Reference No:	2023/62/93545/W
Site Address:	3, Percy Street, Fartown, Huddersfield, HD2 2RX
Description:	Erection of front and rear dormers with associated alterations
Recommending Officer:	Lucy Taylor

DECISION – REFUSED

Officer Report.

Proposal: Erection of front and rear dormers with associated alterations

Drawing
Proposed Plans and Garage Elevations

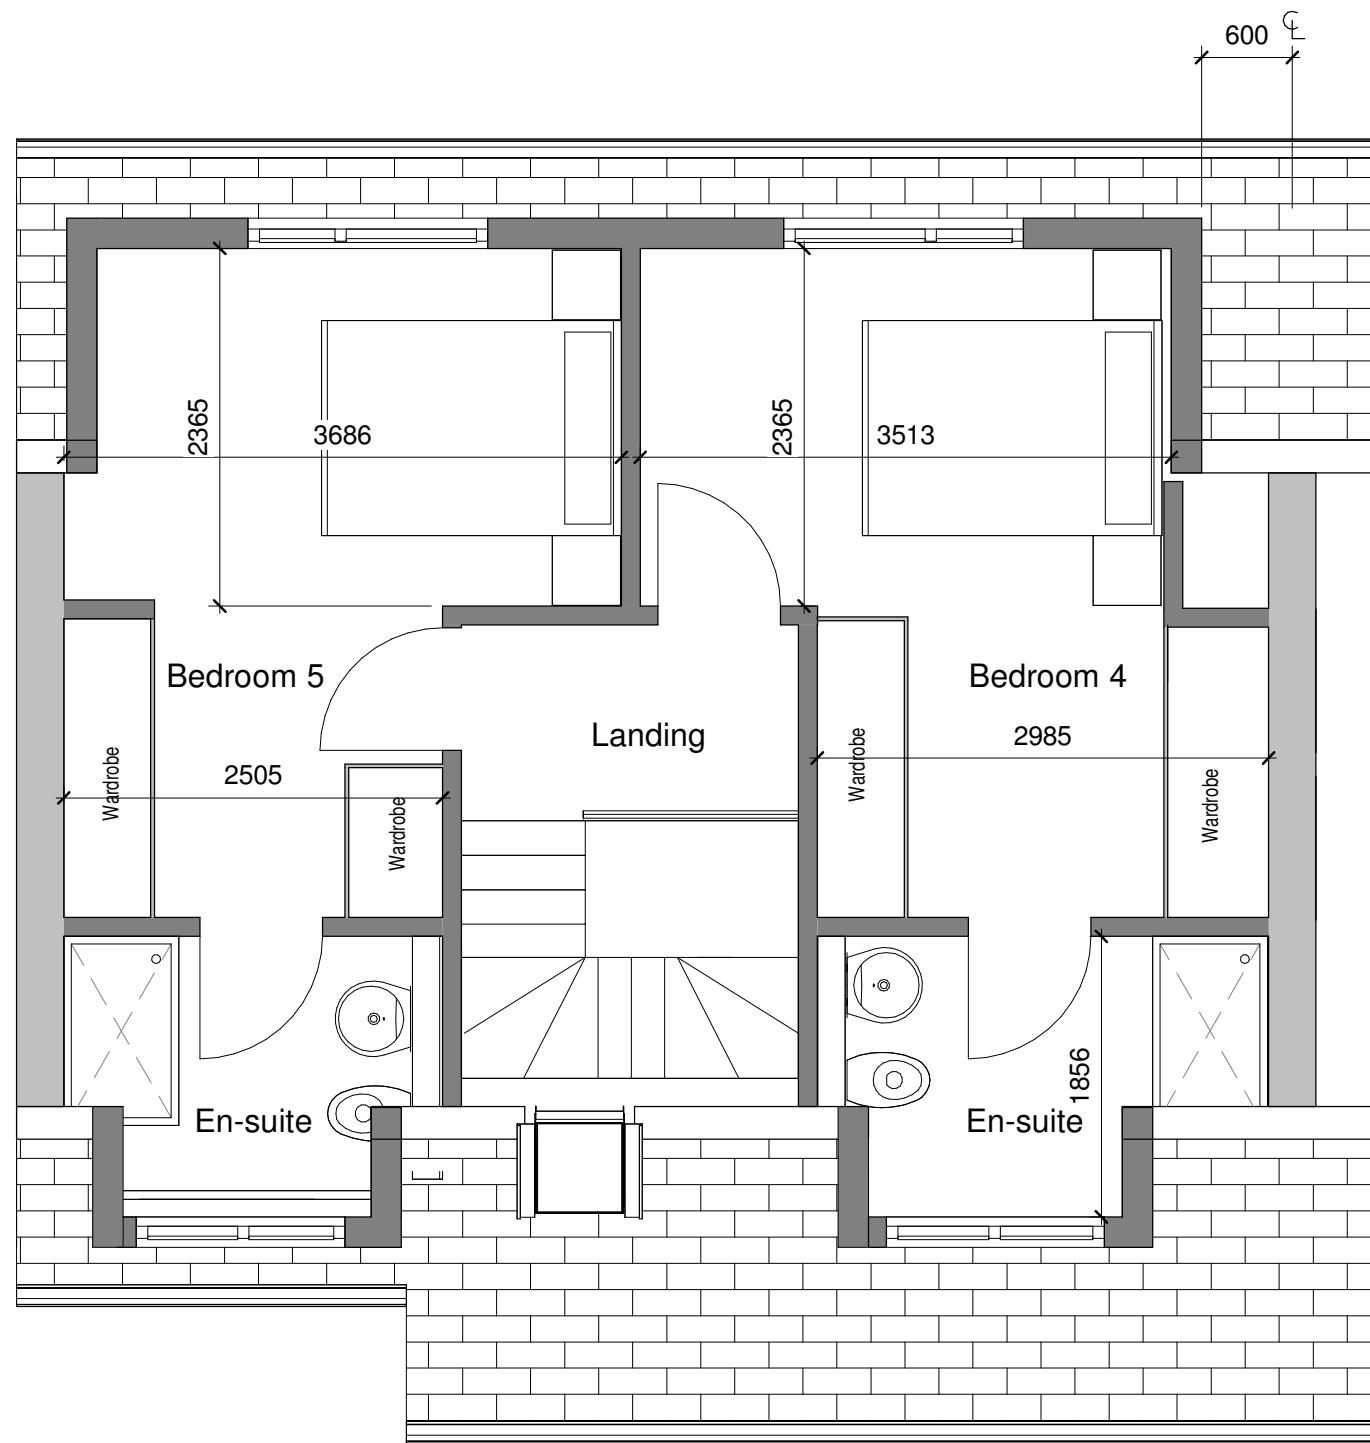
The rear dormer proposed to No. 3 Percy Street would be a box like structure, built across the roof plane of the host dwelling and the previously erected two-storey side extension, which is to be increased in height as part of this proposal. Given the size/scale of the proposed rear dormer, as well as it's width across both roofs, it is considered that it would result in the building appearing top heavy and cluttered.

Paragraph 5.25 states that *"Ideally, dormers should be located to the rear of a house and should be as small as possible with a substantial area of the original roof retained."* In this instance, the rear dormer would take up a significant extent of the roof plane of the original house, as well as covering some of the rear roof slope of the side extension. Furthermore, the dormer would be set down from the ridge height of the roof by only 0.2 metres. As such, given this, it is considered that the rear dormer would dominate the roof and not read as a subservient addition having a harmful visual impact. This conclusion is drawn given the fact the rear of the property is prominent with a number of rear accesses allowing views of the rear roof slope from a number of public vantage points within the surrounding streets.

Drawing  
Proposed Plans and Elevations

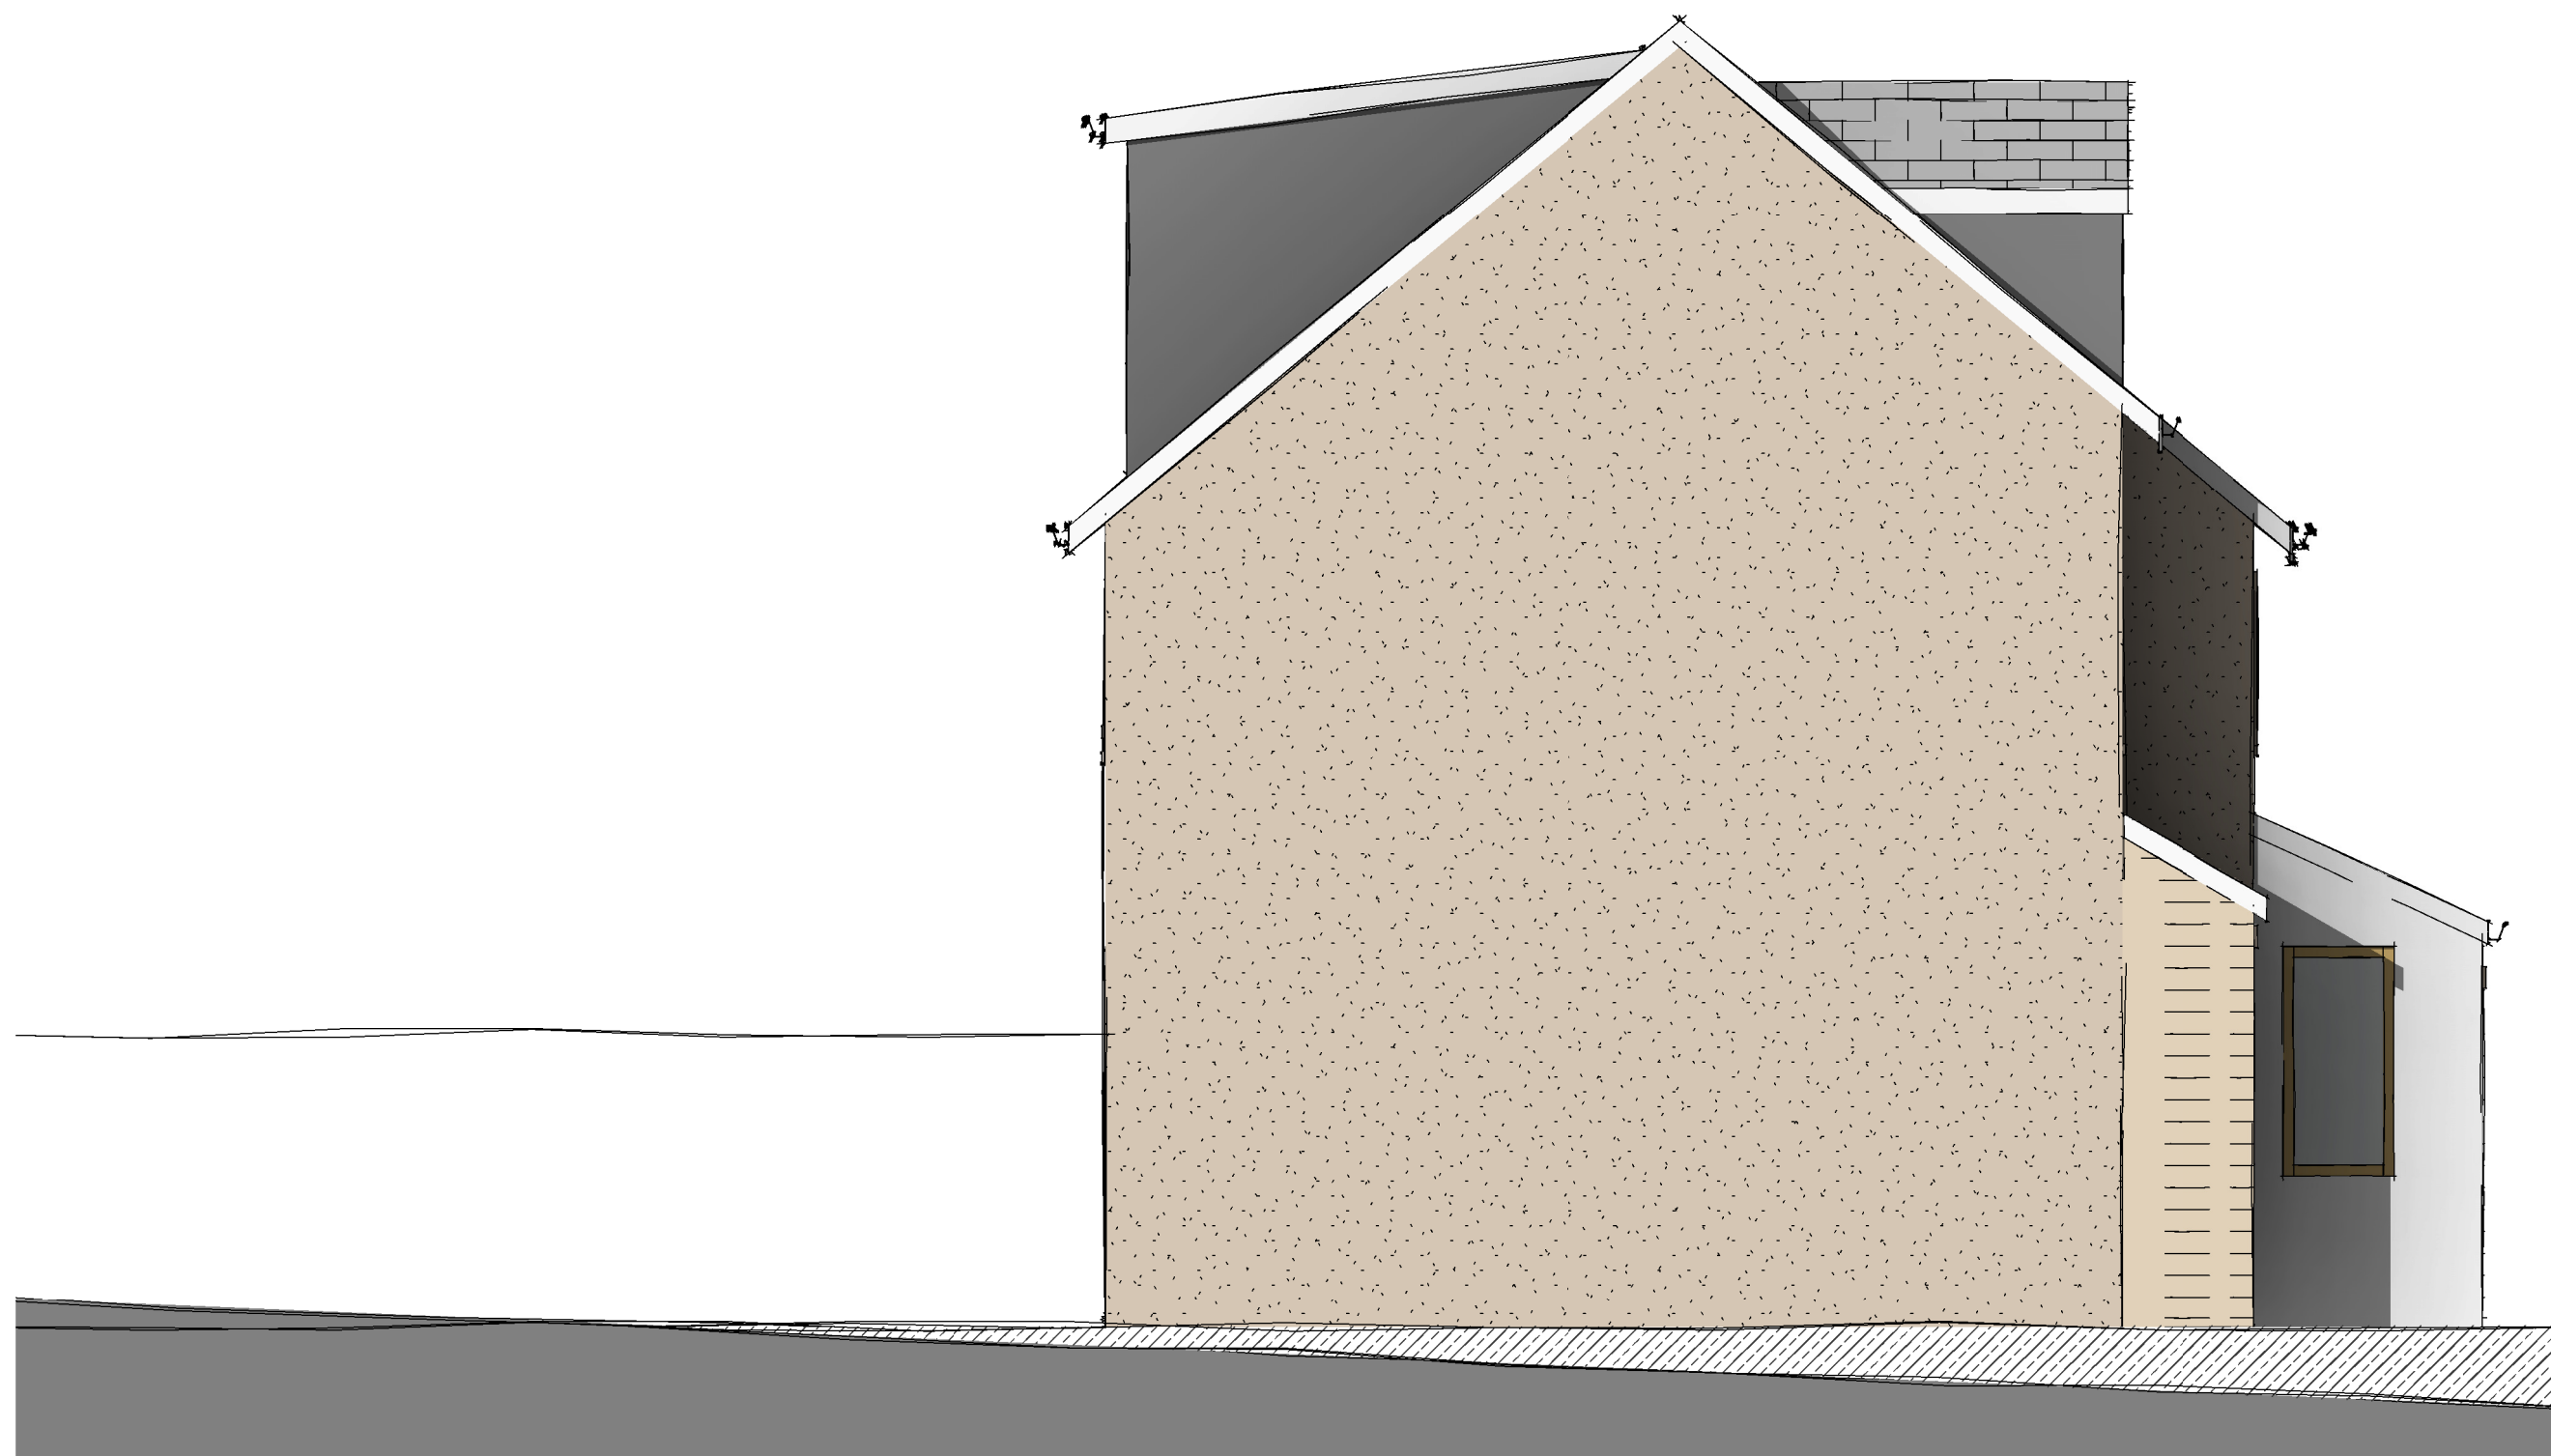
The roof above the previously erected two-storey side extension is to be increased in height, taking the ridge height to the same level as the ridge height of the roof above the original dwellinghouse. This increase in height would have a detrimental effect on the overall design of the two-storey side extension, altering its current subservient appearance / siting to create an extension which would be seen as overly dominant.

Therefore, it is considered that, the positioning of one of the proposed front dormers, within the extended roof slope of the previously erected two-storey side extension would further the impacts of the increased ridge height, adding to the overall extent of bulk / massing which would be created.

Therefore, whilst officers acknowledge the presence of front dormers within the street scene, it is considered that the number of dormer additions, coupled with the re-design of the roof of the two-storey side extension, would see the host property having a level of bulk and massing which is out of character with that of neighbouring dwellings. Officers also draw attention to the fact that
